Planning Application No: 3/2024/1016

Proposal: Regularisation of works including extension to rear ground floor to include internal secure residents cycle store with roller shutter door; re-instate rear boundary wall to 0.74m high; alterations to rear external staircases; upvc windows and doors to front, side and rear; aluminium windows to the front dormer; screening feature to the rear balconies; ground floor bin store; central cladding to front dormer window on third floor; rooflights; external lighting scheme to rear and two electric charging points.

Location: 1 to 7 The Picture House George Street Whalley BB7 9TH

Whalley Parish Council formally objects to the proposed regularisation of works at 1 to 7 The Picture House, George Street, Whalley (BB7 9TH). The current application significantly deviates from the original planning permission and should not be considered a simple regularisation, as the development fails to conform to the previously approved plans.

**DRAWING TITLE**  
 STANDARD WINDOW DETAILS

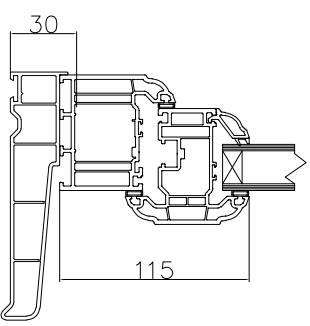
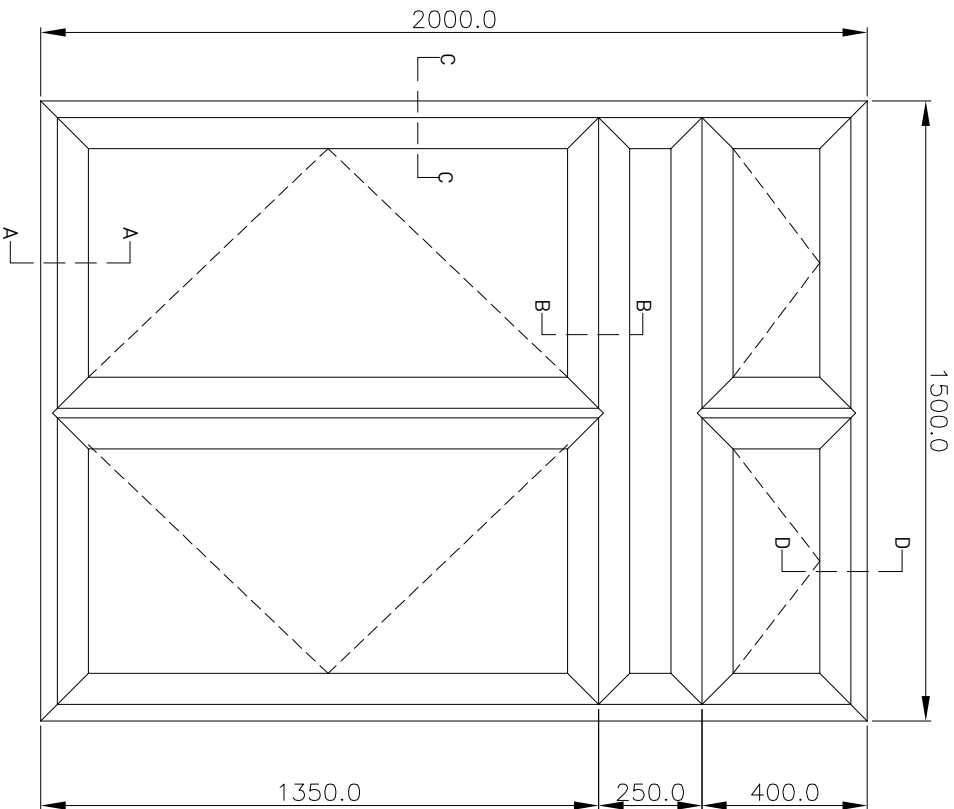
Materials and Design – The materials used should strictly adhere to those originally approved, ensuring the development respects the architectural character of the conservation area. The proposed amendments, including UPVC, are not in keeping with the area's historic and conservation area standards.
